Sent: 28 February 2013 23:44
To: Planning
Subject: S6/2013/0023/FP
Attachments: 4WGL.pdf

3 Wilkins Green Lane
Hatfield
Herts
AL10 9RT

Planning reference S6/2013/0023/FP

TITLE Existing & Proposed Floor Areas	
PROJECT NAME Oak Cottage, 4 Wilkins Green Lane, Hatfield, AL10 9RT	
DRAWN BY E.B	SCALE 1:100 @ A1

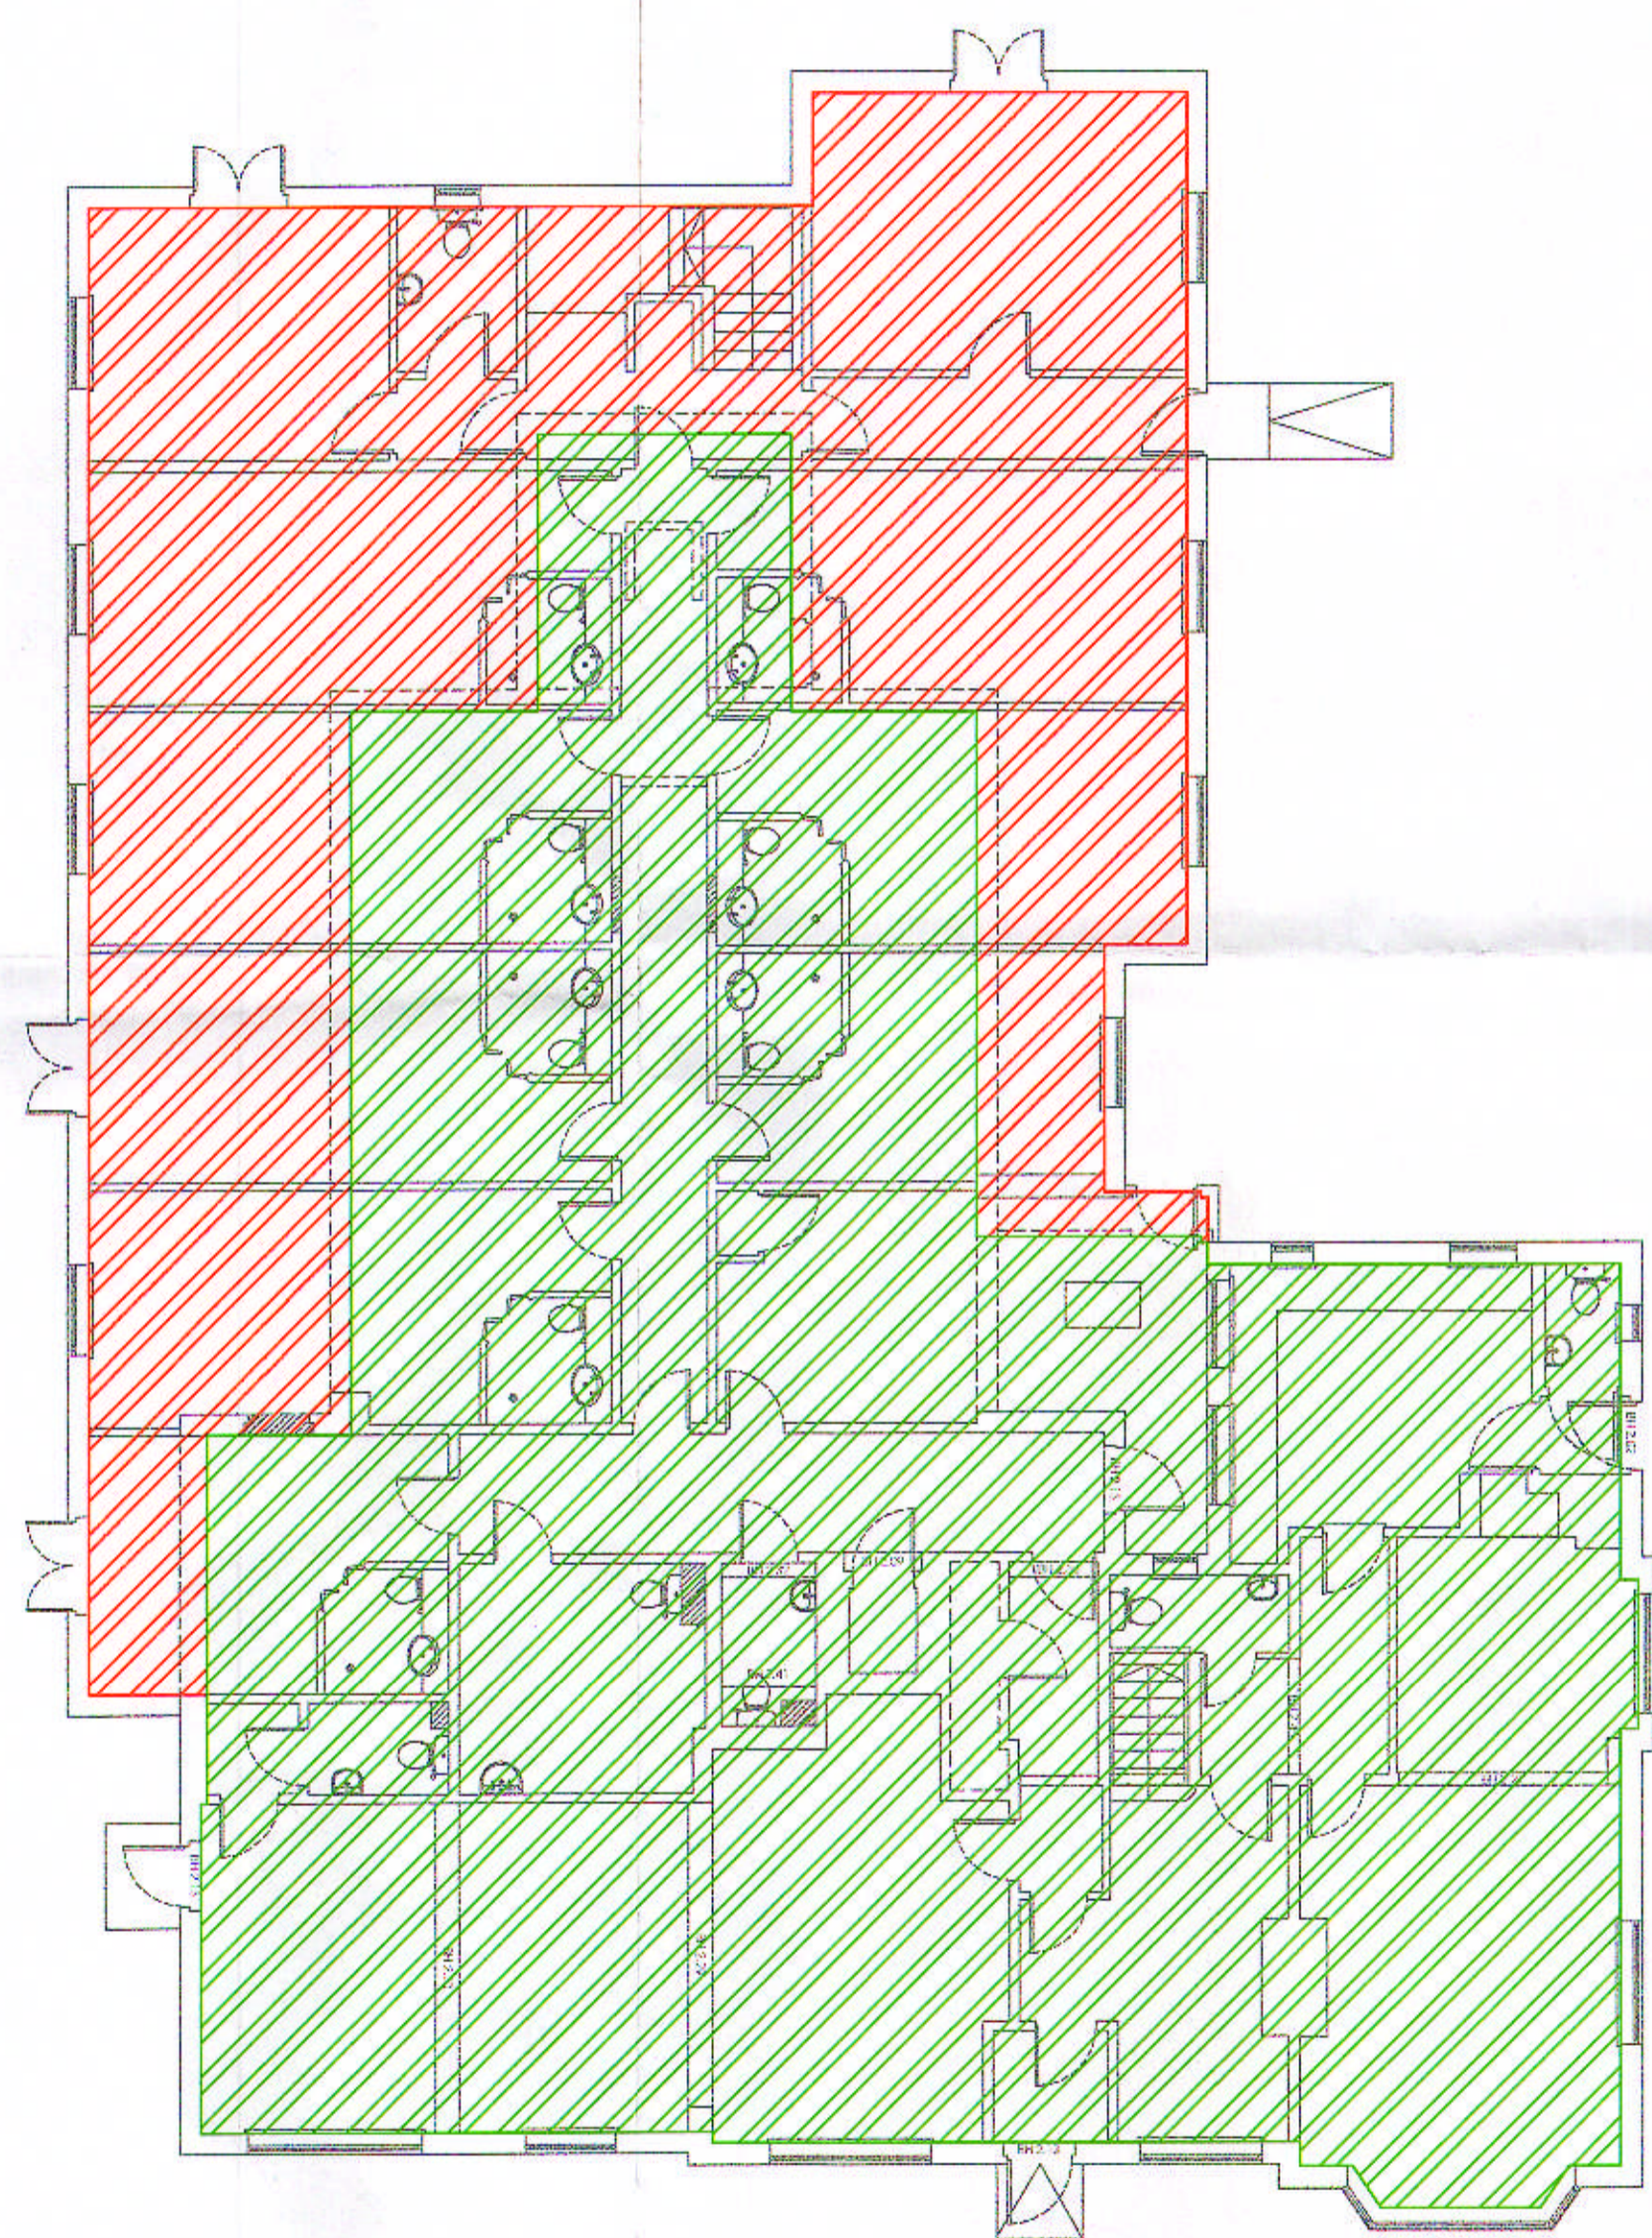
1. **Scale:** The covering letter suggests that this is a re-submission of a previous application (S6/2008/1822/FP) which was approved but which has now expired. In fact, it is considerably more extensive than the earlier application, to which we did not object. It proposes to add a further 50% to a property which is already double its original size; has already had its garage converted into 2 bedroom residential accommodation; and has brick built storage in the rear garden. We have attached a plan that shows the proposed extension in the context of previous extensions. We are concerned at this increased scale which would significantly overdevelop the site.

TITLE Proposed First Floor Plan		
PROJECT NAME Oak Cottage, 4 Wilkins Green Lane, Hatfield, AL10 9RT		
DRAWN BY E.B	DATE August 2012	
SCALE 1:100 @ A1	CHECKED	
DRAWING NO. EL/2012/06	REV. NO. -

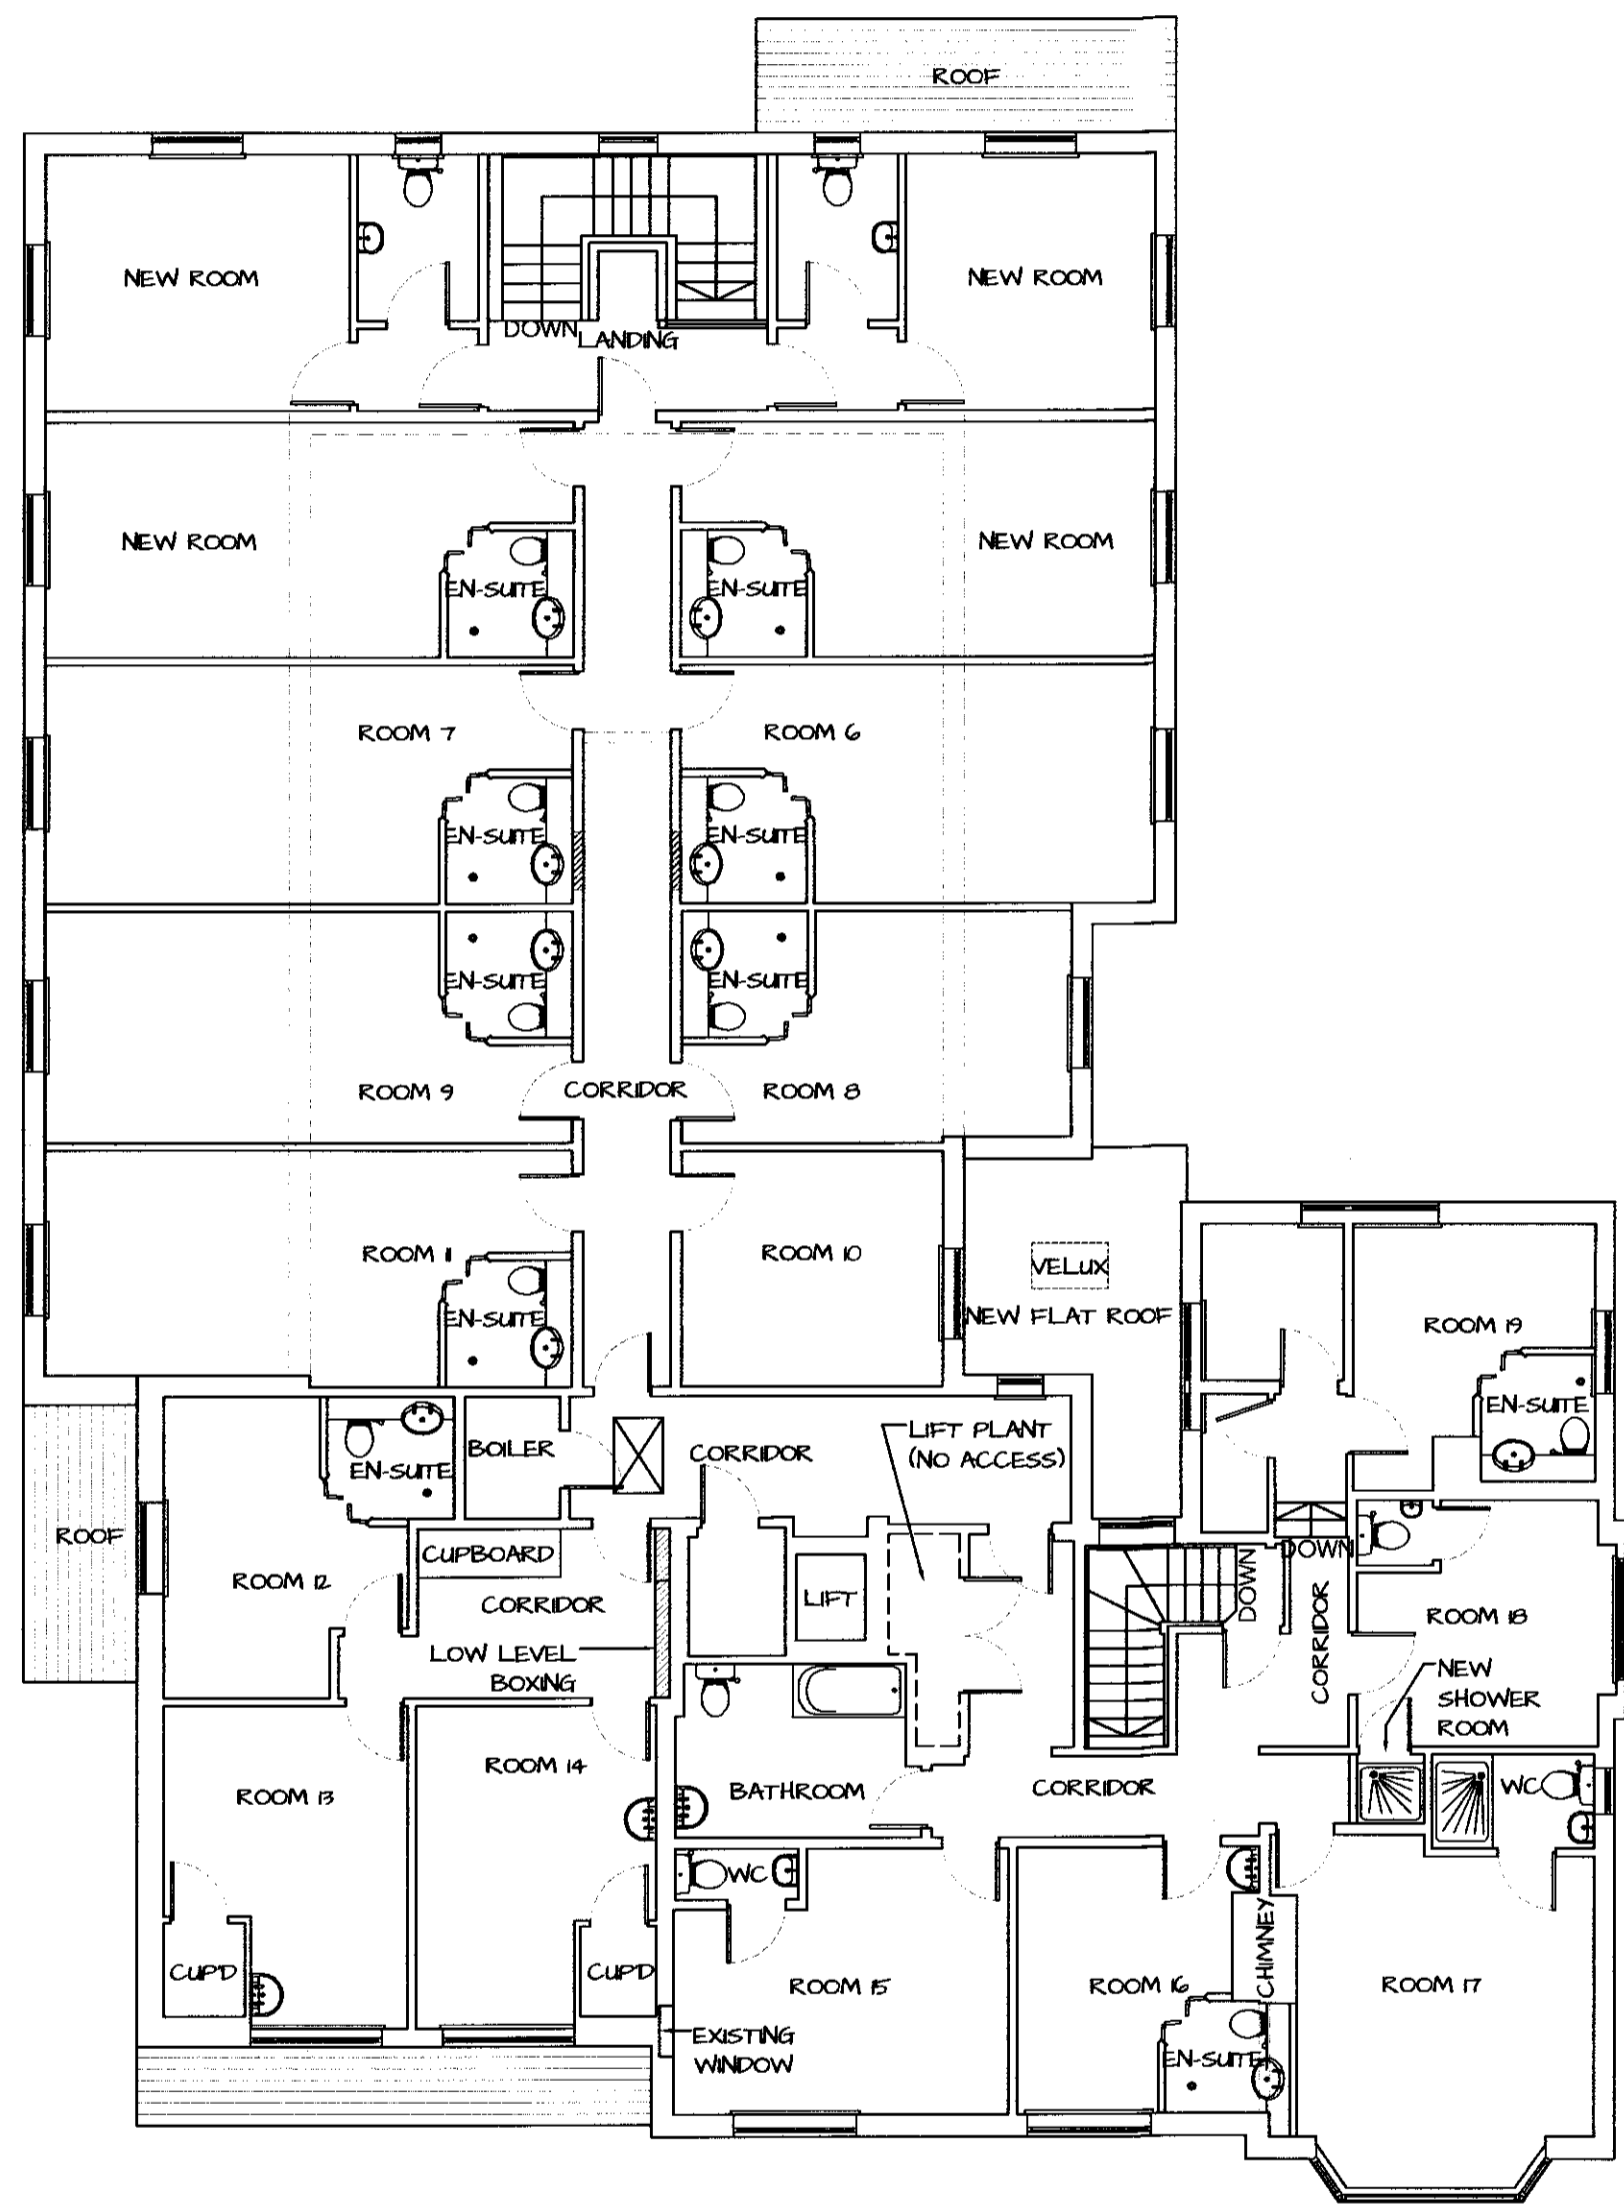
2. **Privacy:** This application includes several clear windows on the upper floor of both the west and east flanks. The application asserts that "*the building will not have a detrimental impact on the neighbours as windows will be positioned the same as the existing elevation*", but this is clearly incorrect. Residents of the new upstairs rooms in the care home would have an uninterrupted view of neighbouring gardens, and those at the far end of the building may well be able to look back at the rear elevation of neighbouring houses. The expired application had the condition that the side windows "*shall be glazed with obscured glass and shall be fixed so as to be incapable of being opened below a height of 1.8 metres above floor level, and shall be retained in that form thereafter.*" At the very least a similar condition should be imposed on this application.

TITLE
Proposed Ground Floor Plan

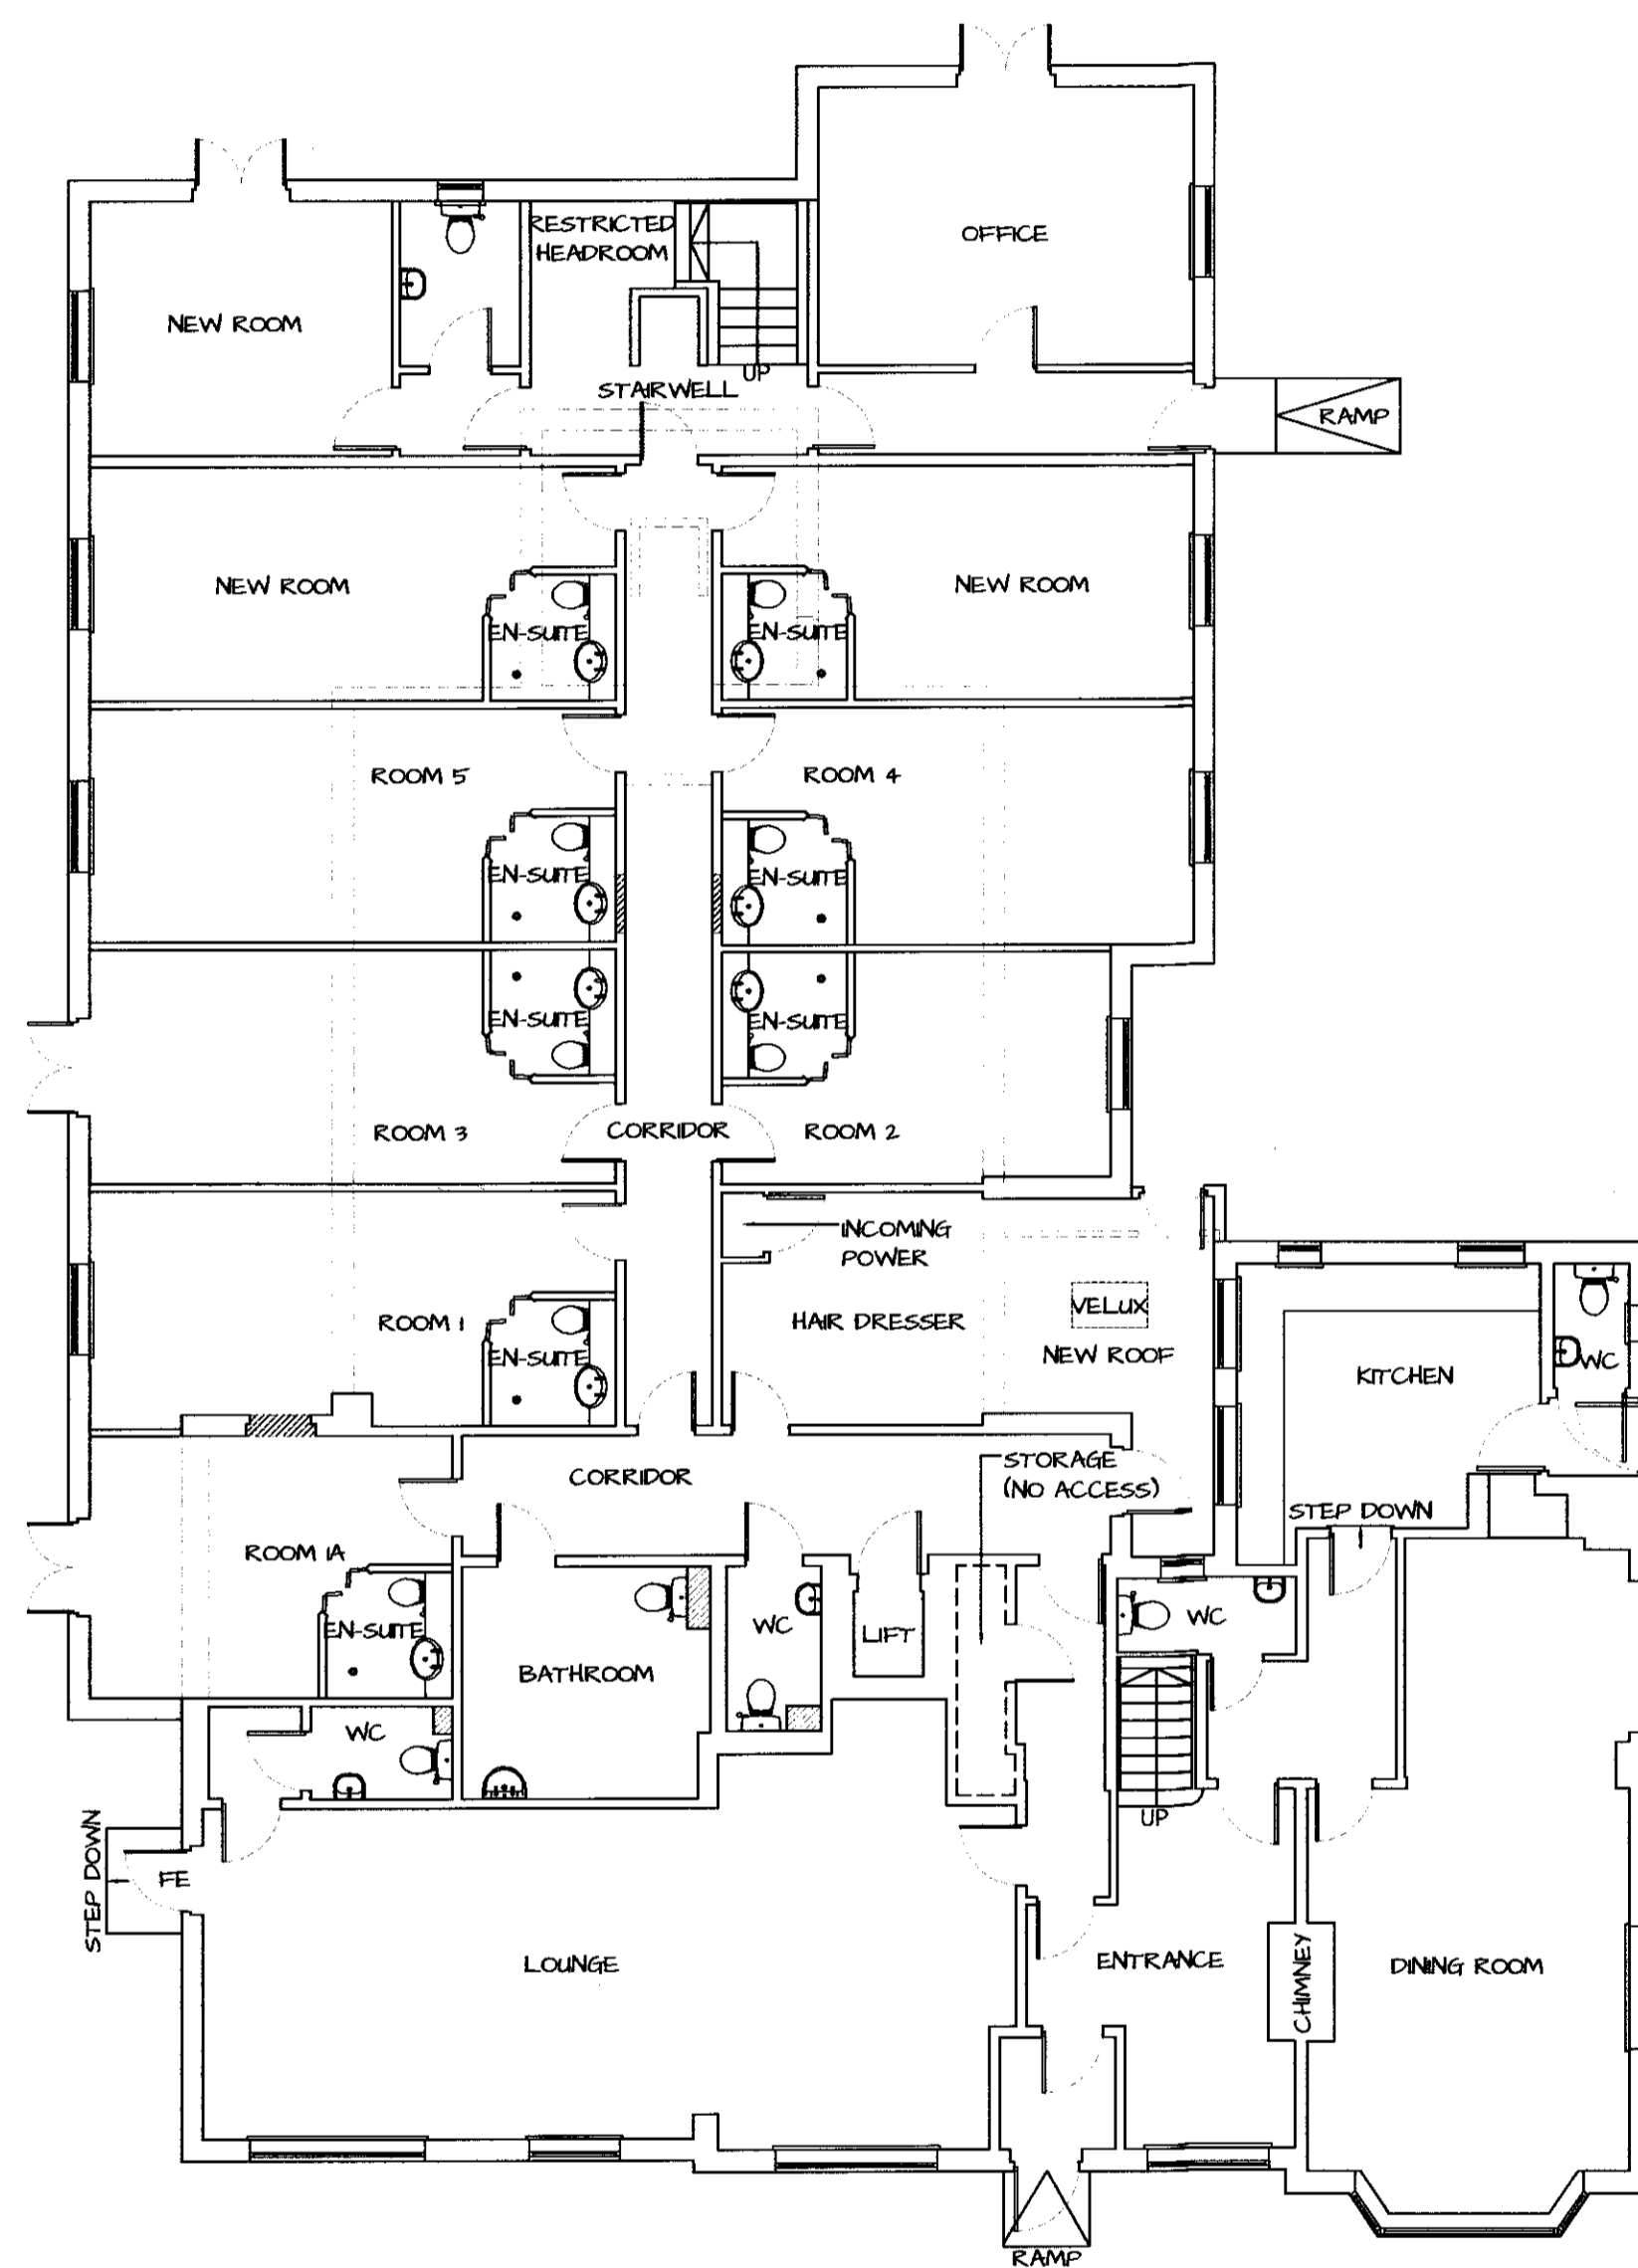
3. **Character:** The new proposal removes front garden to provide parking for 16 cars with a block paved finish, changing the street scene. A significant part of the back garden of the house would be built on. It would represent a significant commercial development in the heart of a residential community, completely out of character with the surrounding properties.
